Project #: 1004354

Application #: 13DRB-70609

Project Name: Krania Subdivison

**CITY OF ALBUQUERQUE
PLANNING DEPARTMENT
July 10, 2013
DRB Comments**

SITE PLAN FOR BUILDING PERMIT

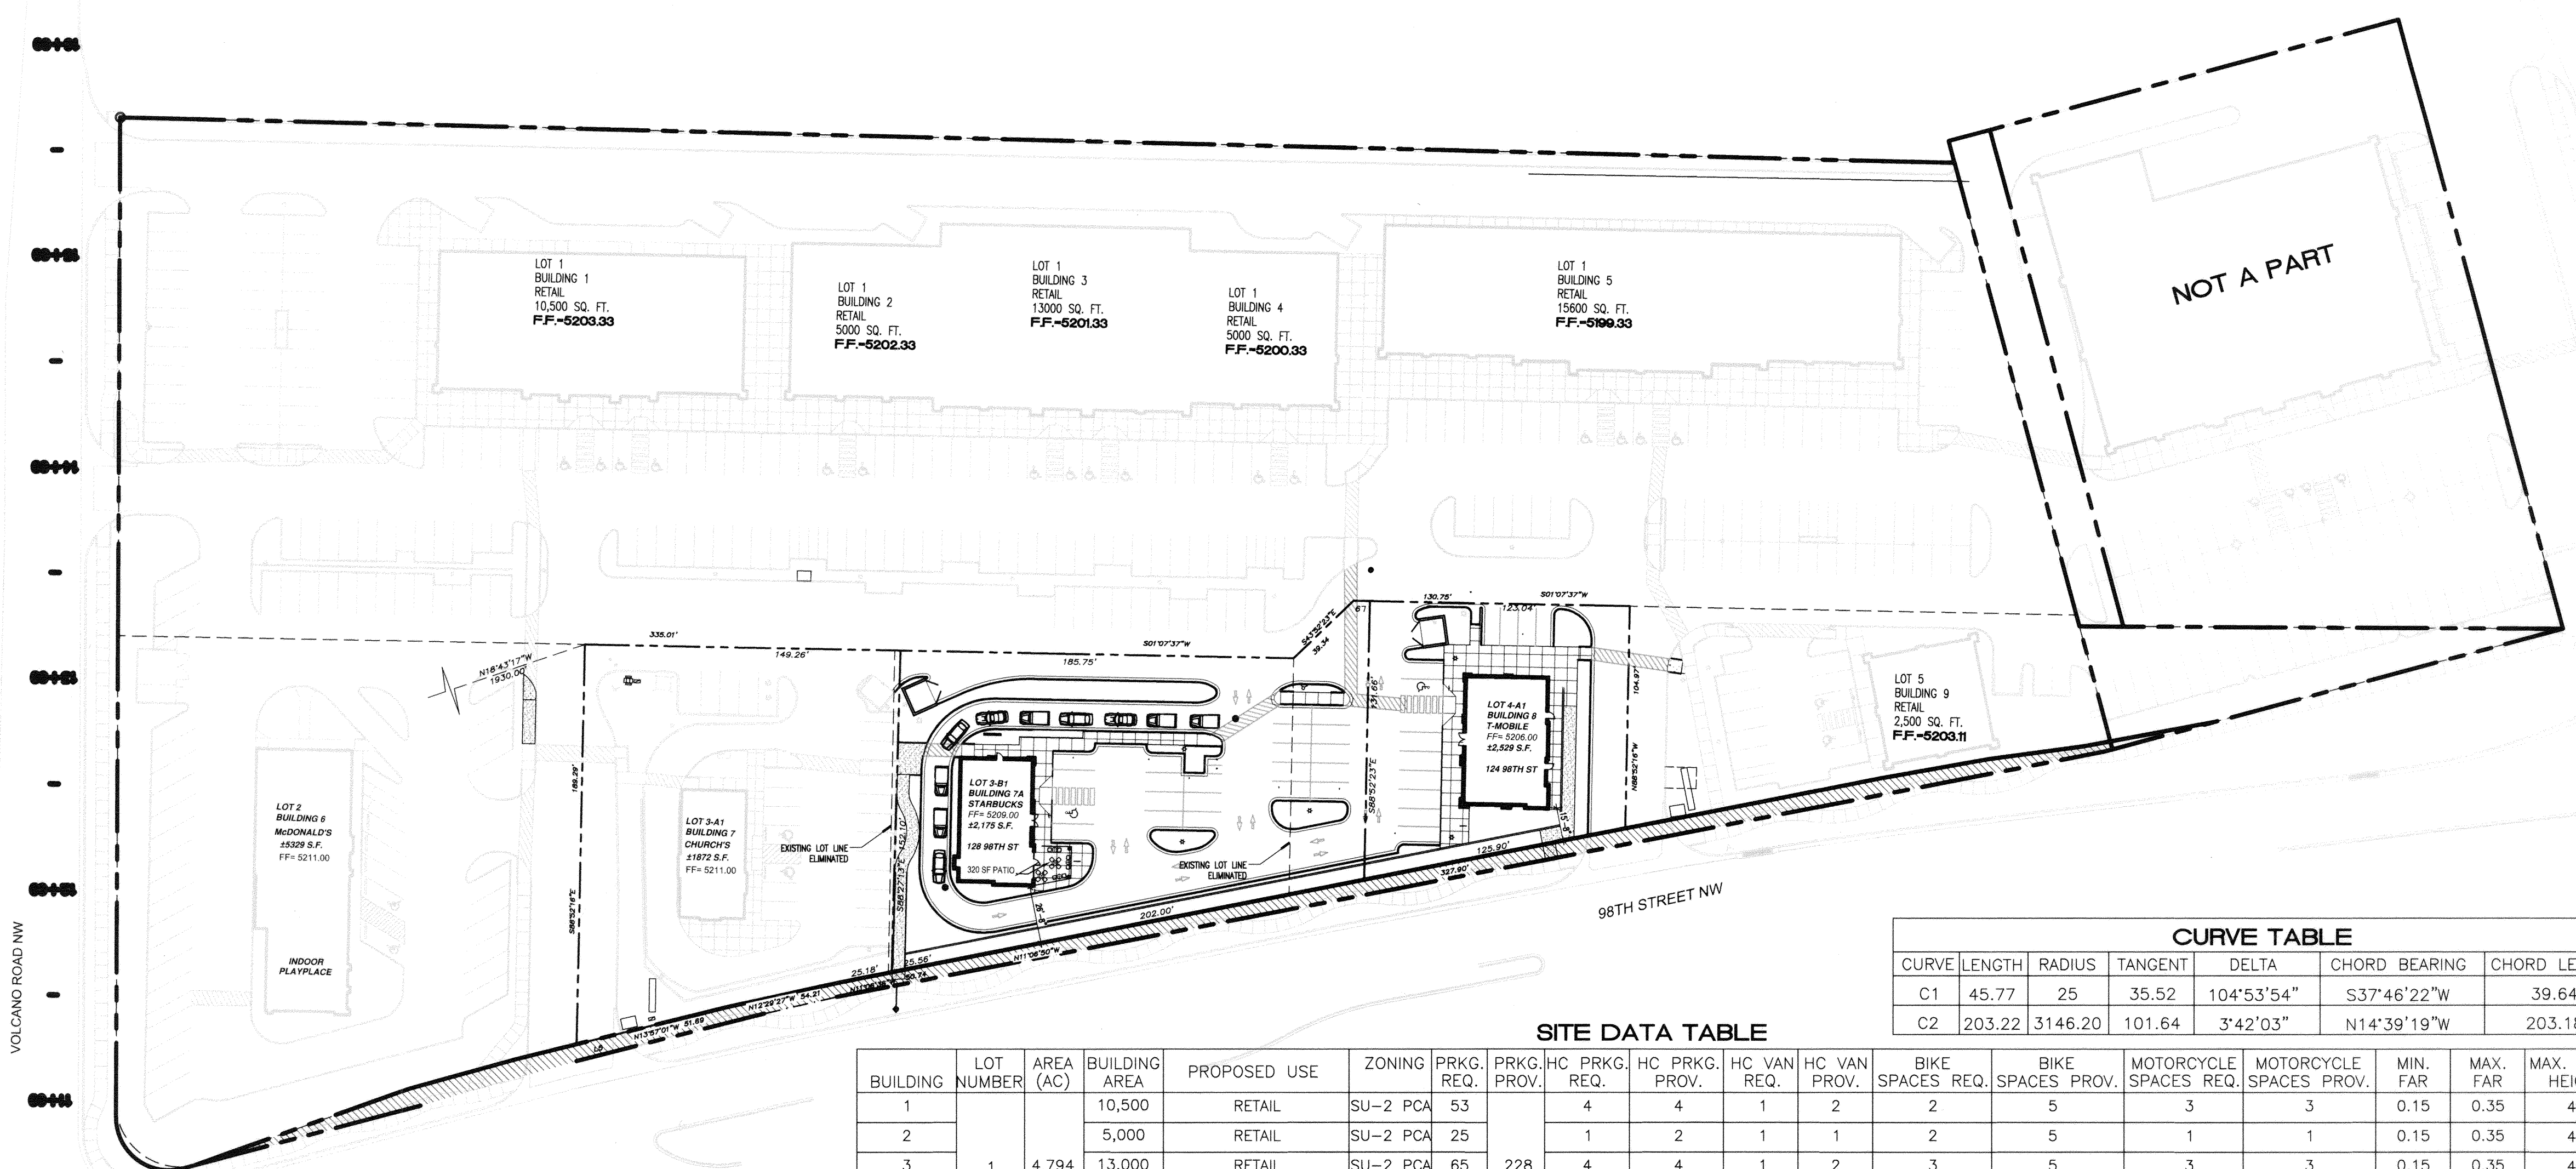
PLANNING (Last to sign): ped access for parking
add the word "adjacent" for Landscape Plat
and copy of Landscape Plan
